Re: SSD-8825-Mod-4 – BESS and Increase Development Footprint

The Department of Planning, Housing, and Infrastructure (DPHI) is in receipt of SSD-8825-Mod 4 for a Battery Energy Storage System (BESS) and increase in development footing at the approved Gregadoo Solar Farm. Wagga Wagga City Council has been requested to provide advice for consideration for the proposal, including details of any key issues and assessment requirements.

Figure 6: Heavy Vehicle Access Route

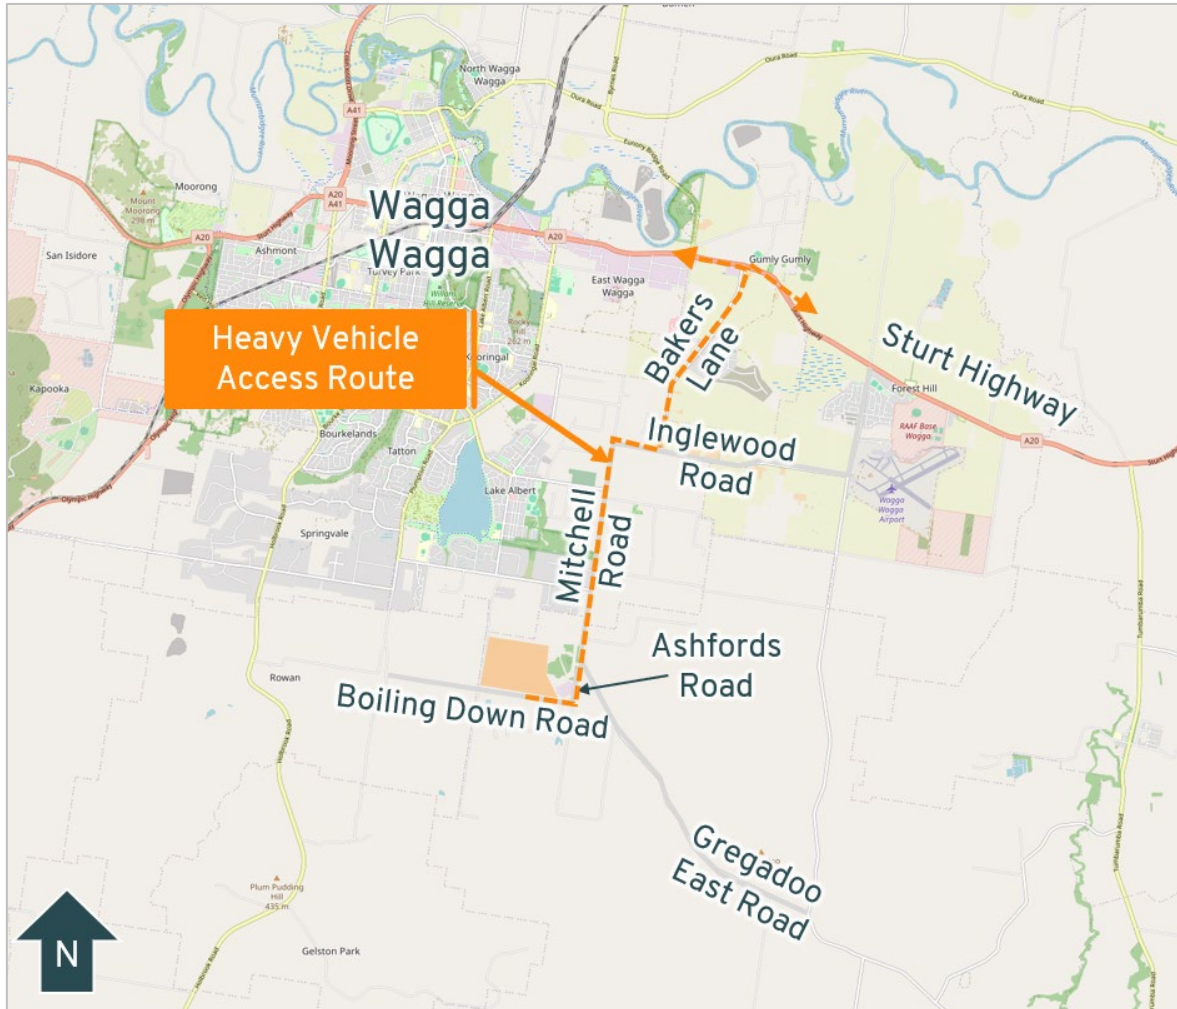
- A particular concern is the proposed increase in traffic generation on unsealed roads in the context of approved and potential further development along Boiling Down Road, and the cumulative impacts on Boiling Down Road and Redbank Road during the construction period.

- Concern is raised with the potential increase in dust generation caused by the potential amendment to heavy vehicle movements. Council recommendation remains that Boiling Down Road and Redbank Road are required to be upgraded and sealed. Use of a watercart to suppress dust is not an adequate solution in this instance.

- The Gregadoo Waste Management Centre (GWMC) is an existing traffic attractor that is situated adjacent to Boiling Down Road. Boiling Down Road is used as an alternate heavy vehicle route to Gregadoo Road for heavy vehicles travelling from Plumpton Road towards the GWMC as they do not need to travel through a School Zone and residential areas.

- Given the proximity of the Boiling Down Road intersection with the GWMC main entrance, what is the potential impact on traffic flows into/out of the GWMC?
